Engineers Comments Regarding Surface Water Drainage

Application Reference:	M/92/25/HH	Reviewer Reference:	ADC/KW/PC
Planning Officer:	Silvie Steiningerova	Date of Review:	09/01/2025
Site Name:	100 Ancton Way, Elmer, PO22 6JR		
Application Description:	Proposed front porch.		
Assessment Number:	1 of 1

Proposed Part Ground Floor Plan

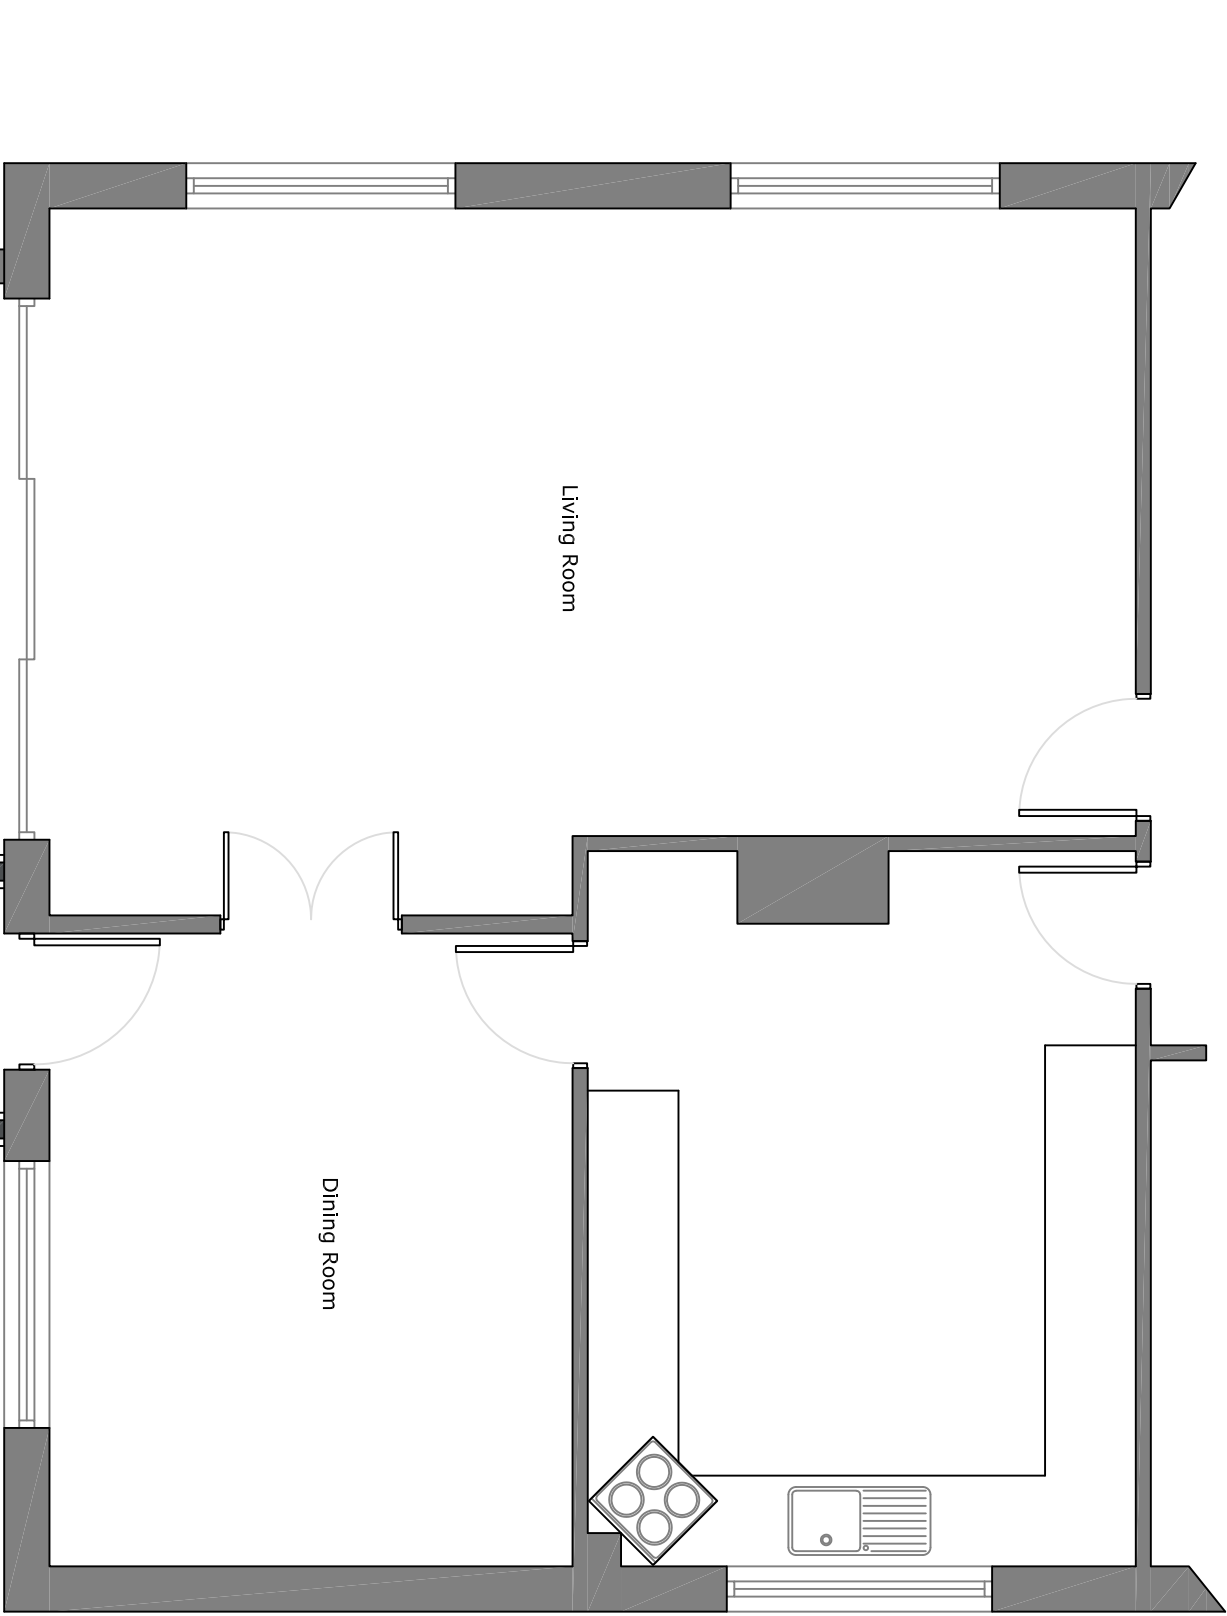
1.1. The designer proposes to drain surface water to soakaways designed in accordance with Part H of the Building Regulations. We support the use of infiltration as the second-highest priority method of surface water disposal (after water reuse); however, the necessary evidence to demonstrate that infiltration is viable has not been provided. Fundamental information, such as groundwater monitoring data and infiltration testing results, have not been provided. Furthermore, should infiltration be proven unviable, no alternative discharge location has been identified. Consequently, it

has not been demonstrated that the site can be sustainably drained, and **we object to the proposal.**

2.1. The applicant has not proposed any interception features. In recognition that the National Planning Policy Framework states that SuDS should be proportionate to the nature and scale of the proposal we are willing to accept that the following interception features can demonstrate compliance without further detailed assessment.
